Final Report - Corrections Required **Application No. PDZD-26-0017**

Description : PDZ Development Plan for the Paint Mines at Reagan Ranch comprised of 102 single-family attached residential lots on 15.283 acres.

Record Type : PDZ Development Plan

Document Filename : Paint Mines at Reagan Ranch PDZ DP_1st Submittal.pdf

GR01
SHEET 6 OF 15
CITY FILE NO.: PDZD-XX-XXXX

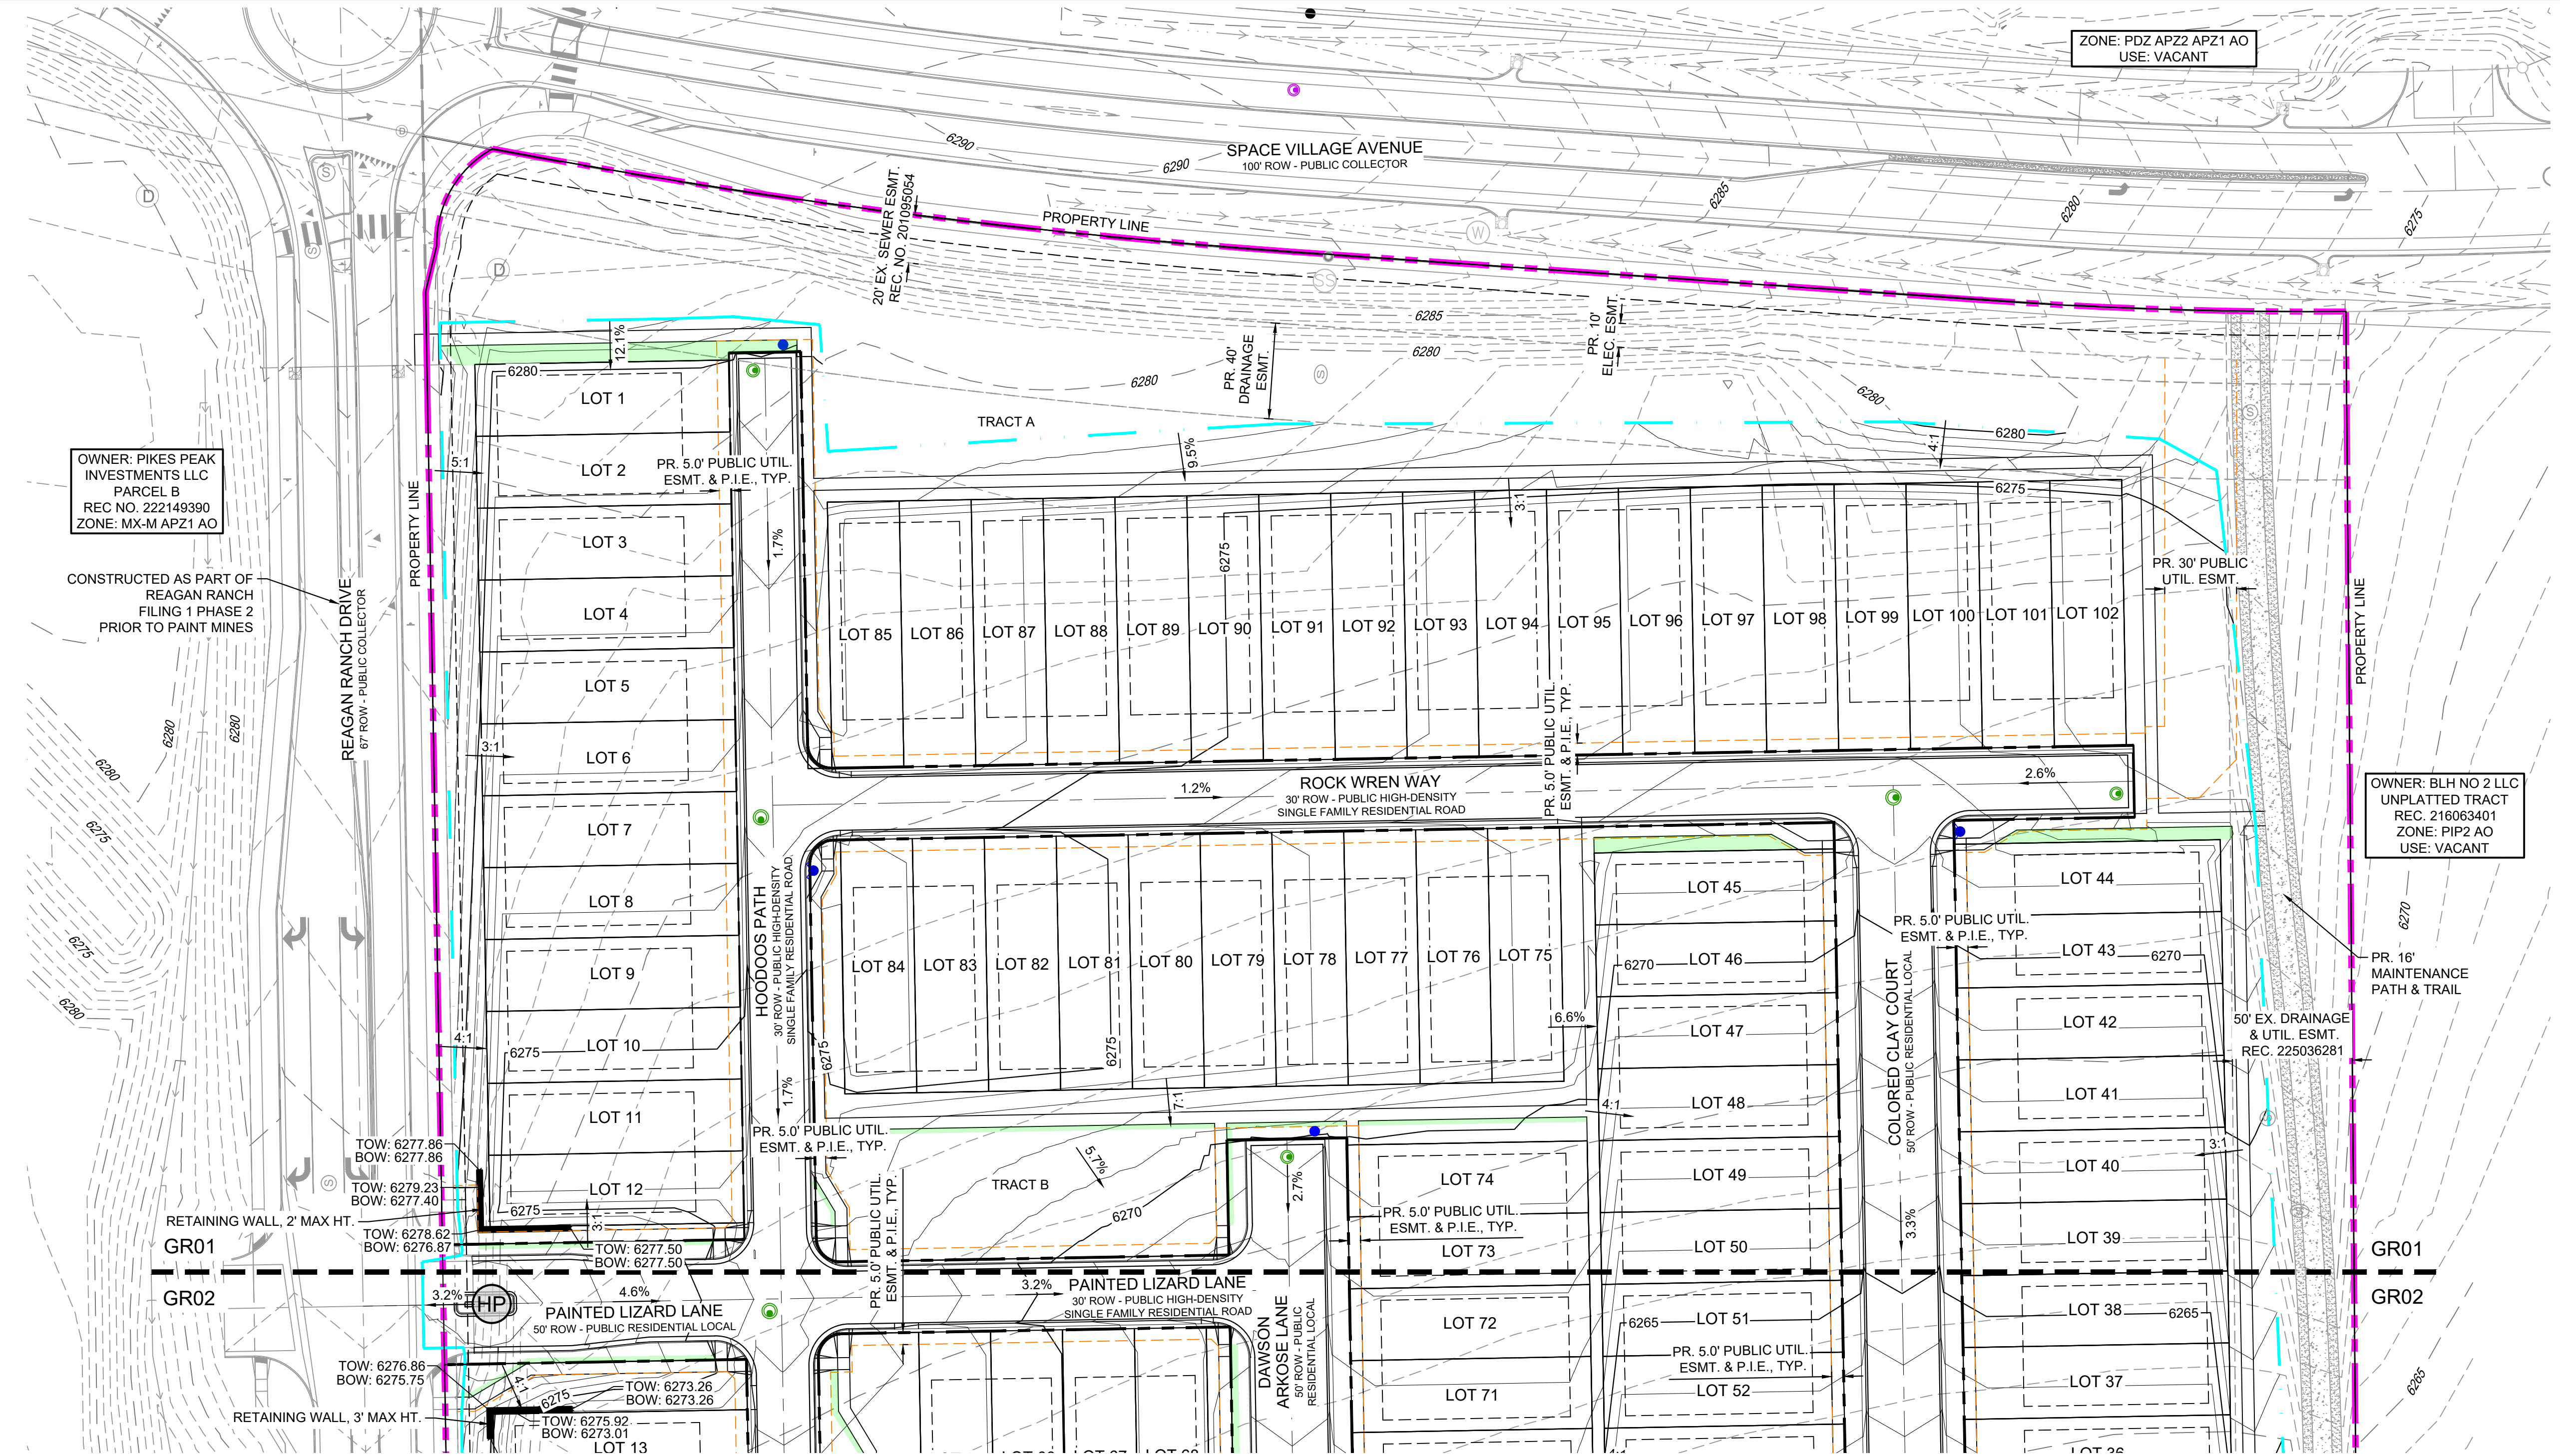
60	6	Sara Rivera : City Engineering - SWENT	Green Infrastructure: the Planned Infiltration Area (PIAs) need to be delineated with a line or a hatch. There must be a leader calling it out as a "Planned Infiltration Area" or it must be included in the legend as "Planned Infiltration Area.". This must match what is being shown in the PDR/FDR. The PIAs must be shown on the Landscape Plans, Grading Plans, and Utility Plans. Please see the revised Development Plan checklist for further clarification: Link
61	7	Sara Rivera : City Engineering - SWENT	Info Only: RPA within public ROW is not allowed without City Engineering approval. City Engineering will review and comment upon this during its Development Plan review.
62	7	Sara Rivera : City Engineering - SWENT	Info Only: The proposed Permanent Control Measure (PCM) will require a separate set of construction plans to be submitted to the Stormwater Enterprise (SWENT) for review and approval. Please contact the SWENT reviewer for a copy of the requirements of this plan. Please note that water quality assurances in the amount of the total cost of the PCM will be required prior to the approval of the construction plans. Plans must be submitted directly to the SWENT reviewer. These plans must be approved and included in the building permit set prior to the issuance of a building permit on the project. These plans must also be approved prior to the Final Phase of the Grading and Erosion Control Plan.

LP1.00
 12 OF 15

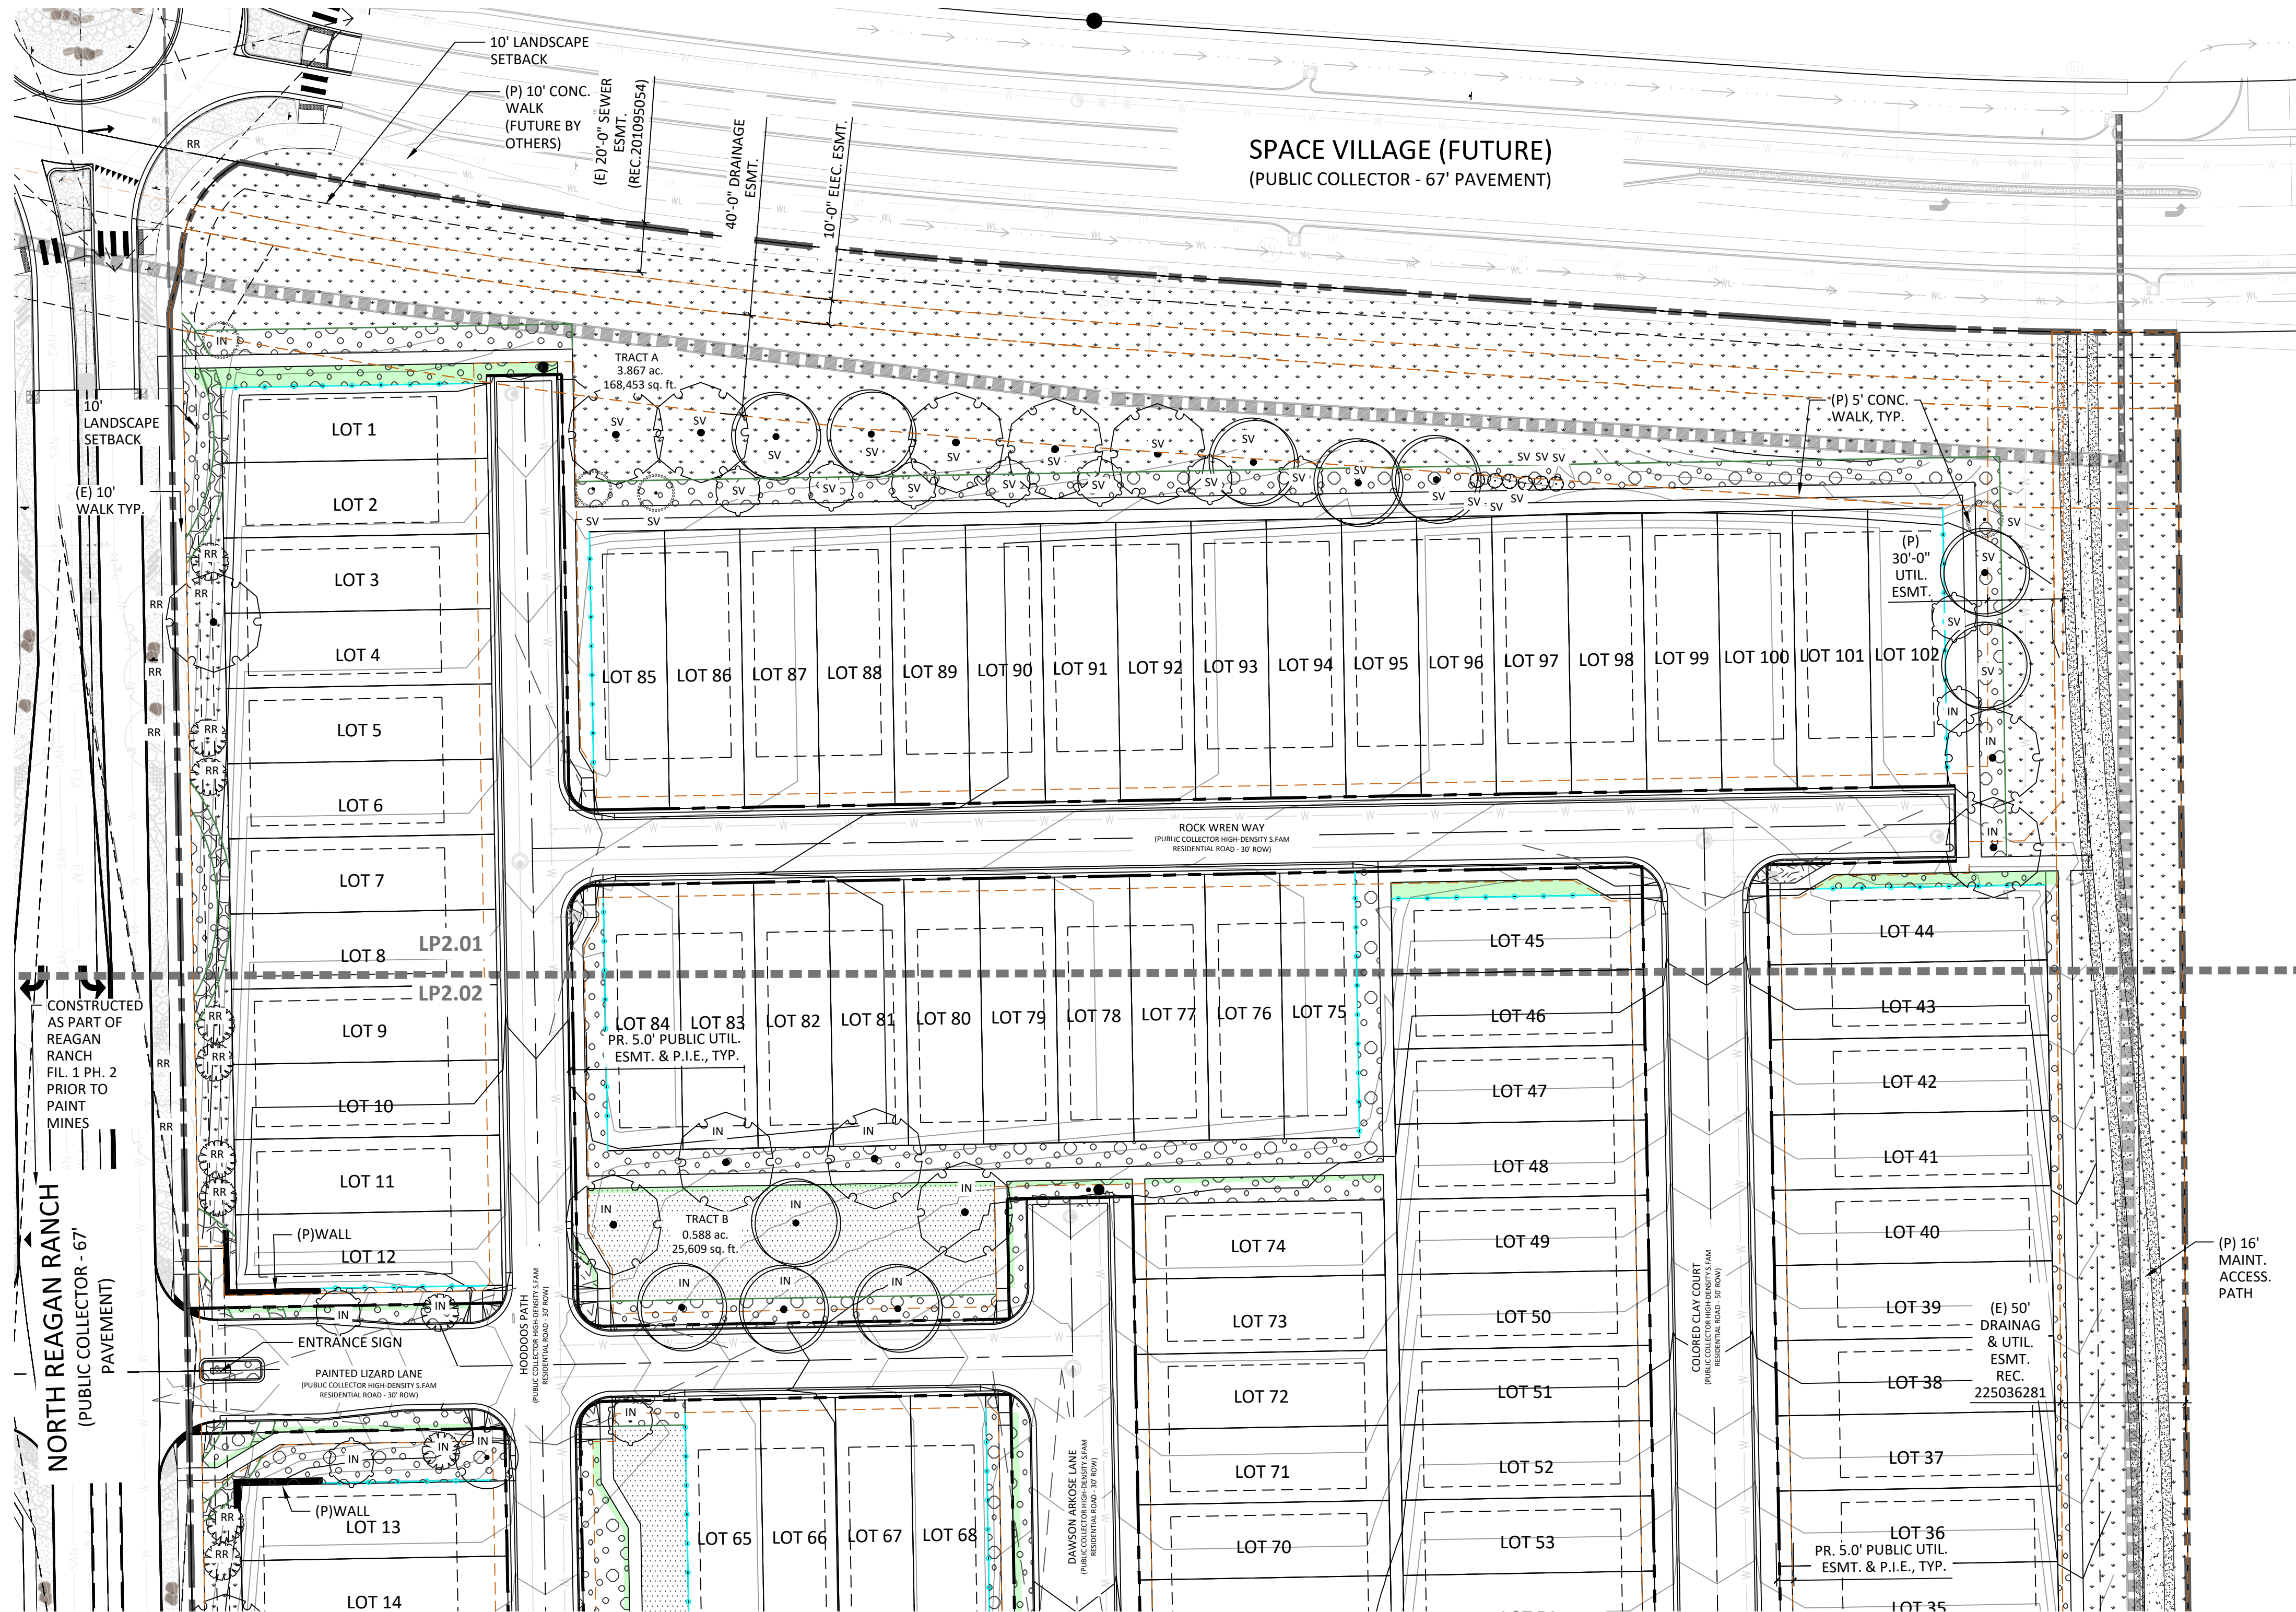
Comment ID	Page Reference	Reviewer : Department	Review Comments
44	12	Patrick Dosch : Col Springs Utilities	Add a note stating, "Trees shall not be planted in an easement and shall maintain a 15-foot minimum separation from water and wastewater mains, or services and a 6-foot minimum separation from electric and gas distribution lines."
43	13	Patrick Dosch : Col Springs Utilities	Tree within 15' of water main
45	14	Patrick Dosch : Col Springs Utilities	Tree(s) in conflict with hydrant, confirm horizontal clearance
46	14	Patrick Dosch : Col Springs Utilities	Tree within 15' of water main
47	14	Patrick Dosch : Col Springs Utilities	Tree(s) within 15' of water main
48	14	Patrick Dosch : Col Springs Utilities	Tree(s) within 15' of wastewater main
1	1	Jason Jacobsen : Comcast	Comcast has no issues.
68	1	Allison Stocker : Planning	where are these located? I only see one small parking area
72	1	Caroline Miller : Planning	Citywide Development Impact (Police & Fire) Fees are applicable to this development, City Code 7.5.532. A CDI and School Fee estimate has been uploaded to this Accela file for applicant review. These fees are subject to change, and due at time of building permit.

19	12	Gregory Stachon : Planning	Ensure that the requirements of COS Landscape Manual Appendix C are met including: 8. All Compact Lot projects with street-oriented lots shall provide one (1) tree per lot and be in either a tree lawn that is at least seven (7) feet wide, or within the front yard of each lot per City UCD Section 7.4.905.B.2.(4c). These trees shall be shown and labeled on the landscape typical(s). 9. For all Compact Lot projects, a recommended tree species list shall be provided with the typical(s) and chosen from the current Forestry City Approved Street Tree List.
20	13	Gregory Stachon : Planning	Street frontage trees are more than 50' from the property line. Ok due to avoiding utility easements but note as an alternative landscape adjustment on the site category chart.
23	13	Gregory Stachon : Planning	call out the height and material of any proposed fences and walls on landscape plan as applicable.
